Letter No. **04/8752/97**

Sub: CMDA - planning permission - Construction of Polytechnic building in S.No.167, 168/1, 168/3, 169/2A1, 2A2, 2A3, 2B, 2C, 2D, 2E and 171 of Minilichery village, Chrospet/Chennai - Development charges and other charges to be remitted - Reg.

The proposal/Revised plan received in the reference cited for the construction of Polytechnic building and Polytechnic in the site bearing S.No. 167, 168/1, 168/3, 169/2A, 2A2, 2A3, 2B, 2C, 168/2D, 2E and 171 of Minilichery village, Chrospet, Chennai is under scrutiny.

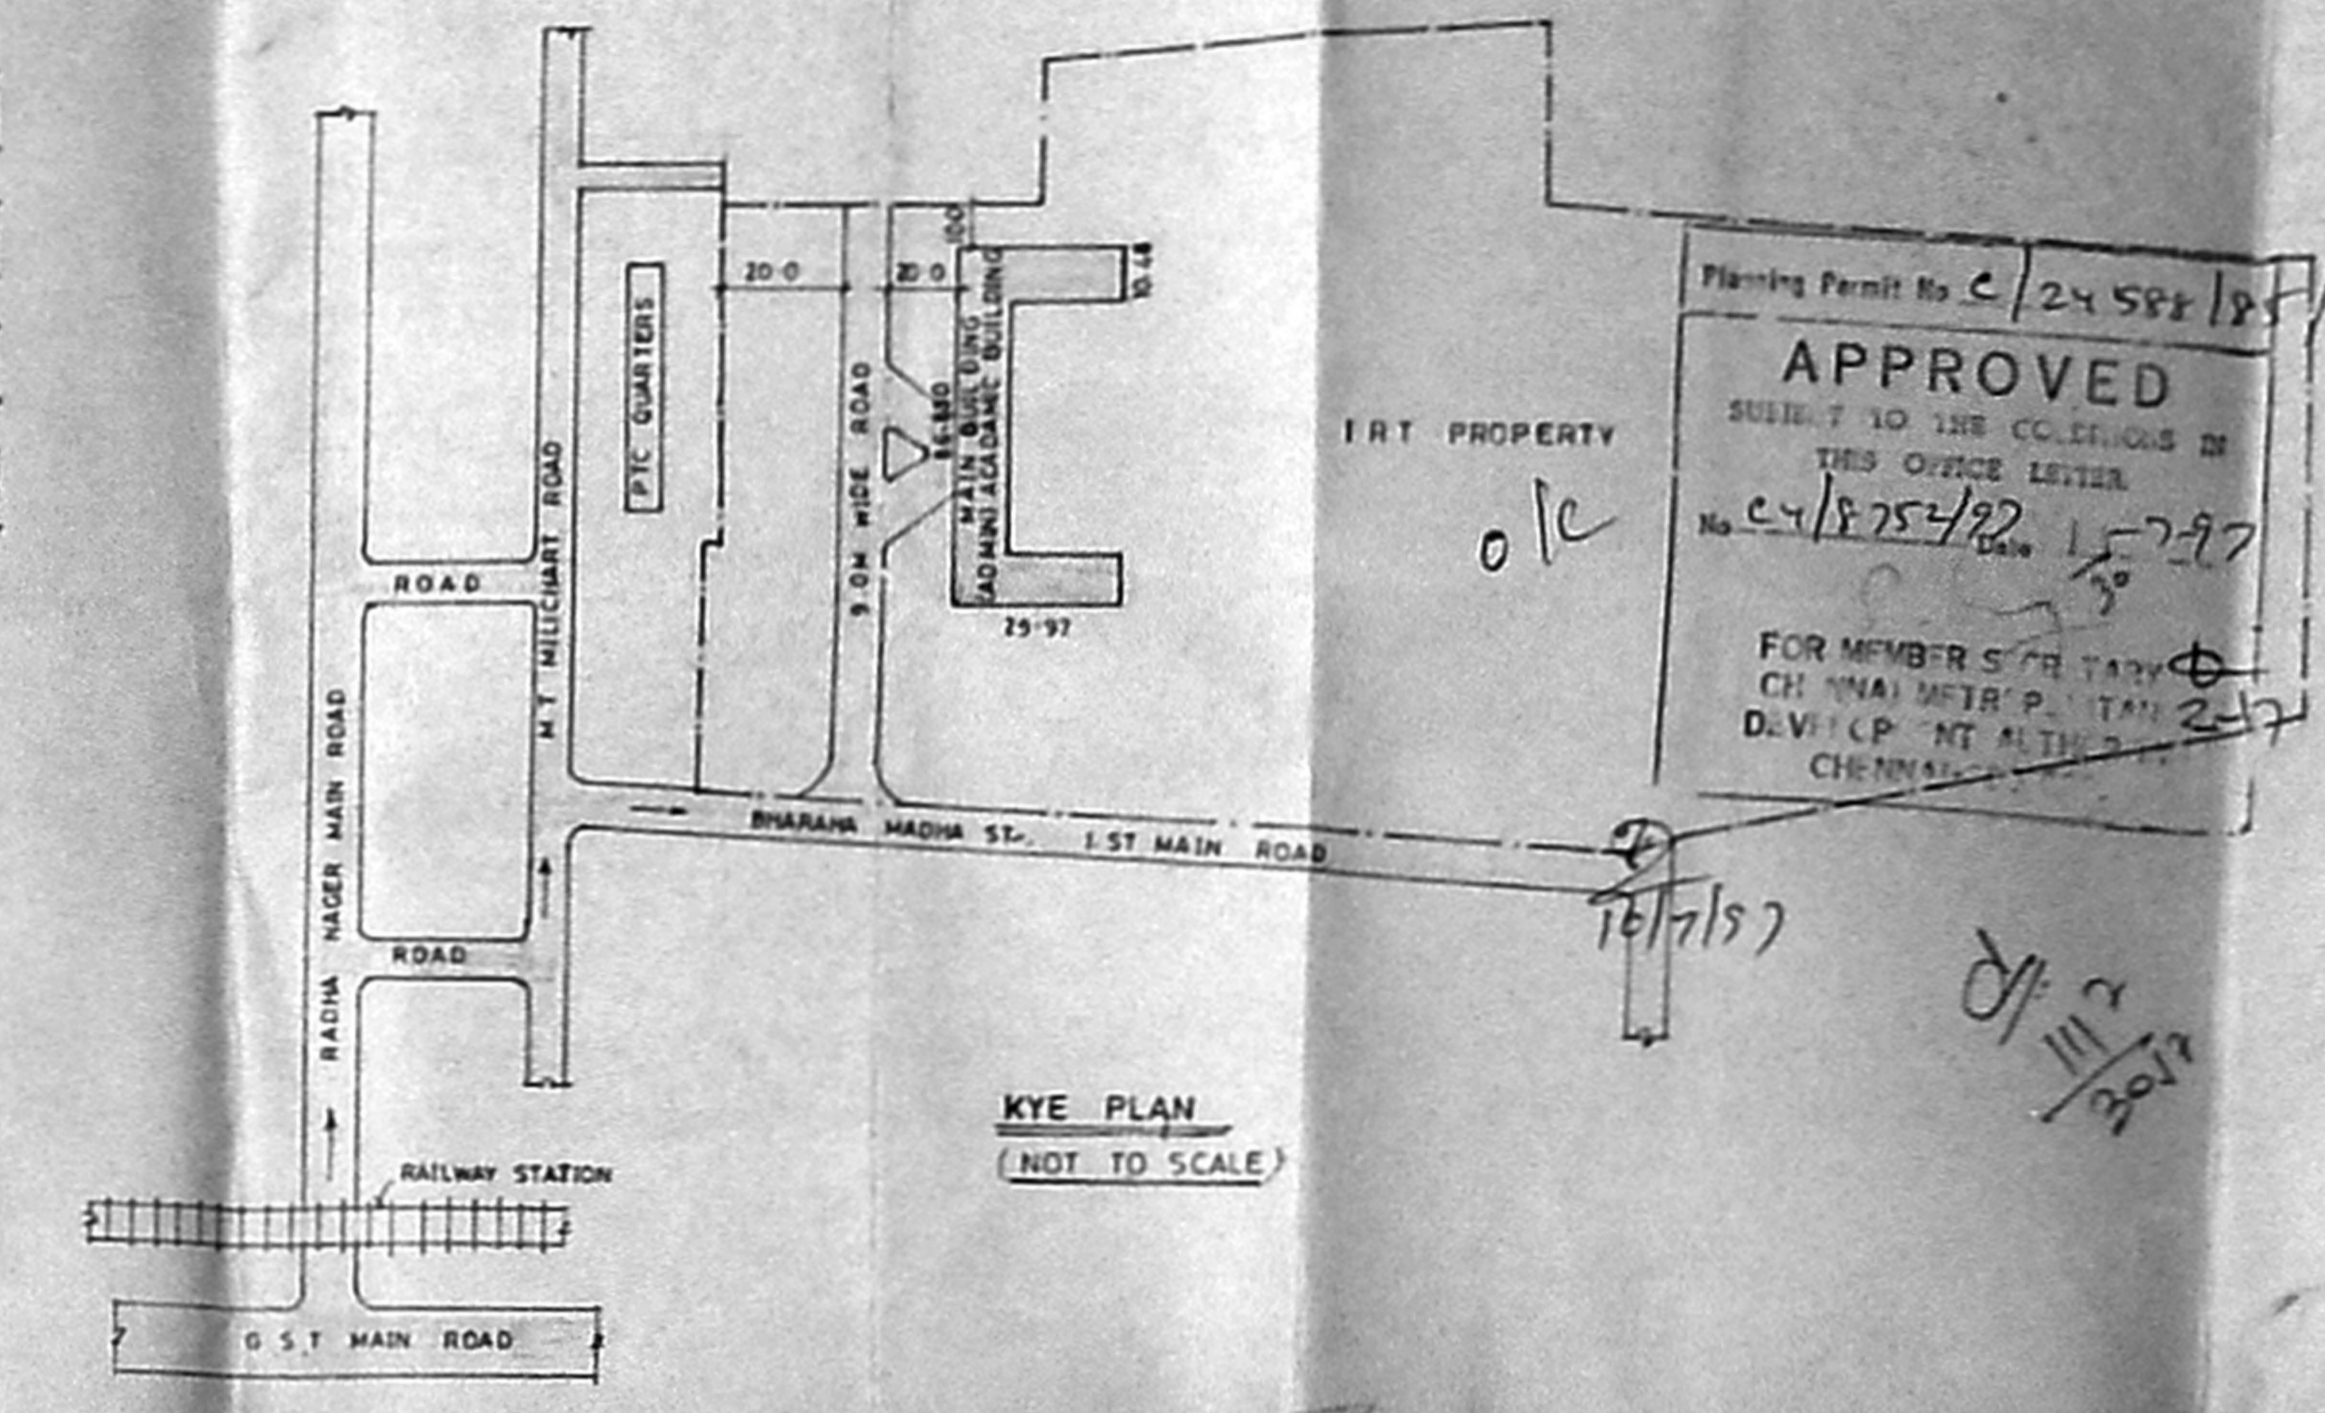
- a) Rain water conservation regulations stipulated by Chennai Metropolitan Development Authority should be adhered to strictly.
- a) Revised site plan showing the correct measurements of site boundary as on handing ^{over} area sketch/FMB sketch; if FMB sketch as furnished a ^{over} ~~combined~~ FMB sketch also to be furnished.

- ** b) Revised detailed plan showing the corridor width as 2.00 M for the Main Building.
- c) Revised site plan/detailed plan for showing the all the existing structures and correct set back details as on site condition, and showing the correct around measurements of all structures.
